Our ref: DOC20/834620

Your ref: DA75/256-MOD 5

Subject: EES comments on Modification application for Spring Farm Quarry – extension of time (DA75/256 MOD 5) – 186 Macarthur Road, Spring Farm

Attachment A**Subject: EES comments on Modification application for Spring Farm Quarry – extension of time (DA75/256 MOD 5) – 186 Macarthur Road, Spring Farm**

**Figure 3. Final Landform and rehabilitation management plan**

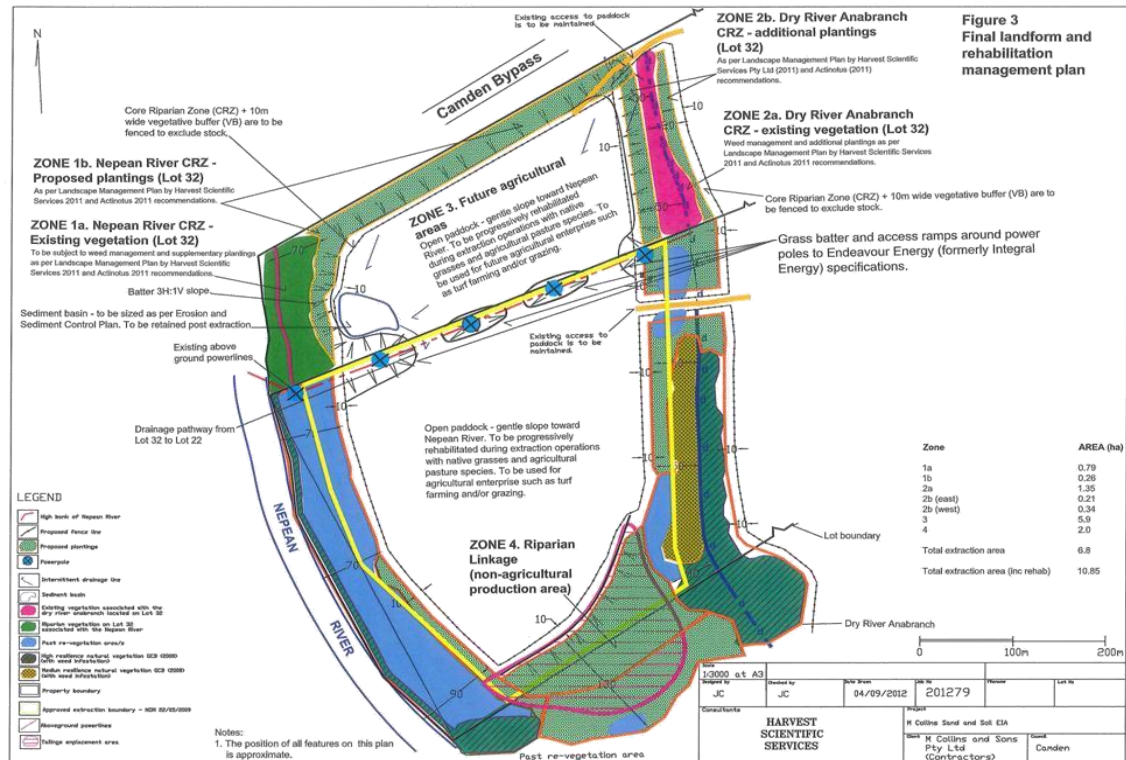
- Nepean River Riparian Vegetation (Zone 1a and 1b)
- Dry River Anabranh Vegetation (Zone 2a and 2b)
- Agricultural Production land (Zone 3)
- Riparian Linkage Zone (Zone 4) (Section 4, page 10 of Appendix K).

- Appendix M states “the native vegetation structure has benefited from concerted woody weed control and revegetation efforts over recent years and is currently presenting in good condition with limited weed diversity” (page 9). This implies the riparian linkage has been replanted
- Figure 30 (Final landform and rehabilitation management plan) in the EA for the MOD 5 proposal shows the riparian linkage is proposed to be planted (page 78). EES notes it is not shown on Figure 16 - Extraction and Rehabilitation Staging Plan in the EA (page 28).
- Figure 3 (Final landform and rehabilitation management plan) in Appendix K shows the riparian linkage (Zone 4) is proposed to be planted.
- Appendix K states “all revegetation tasks will commence upon completion of final landform levels” (page 15)
- Appendix 3 in Appendix K states:
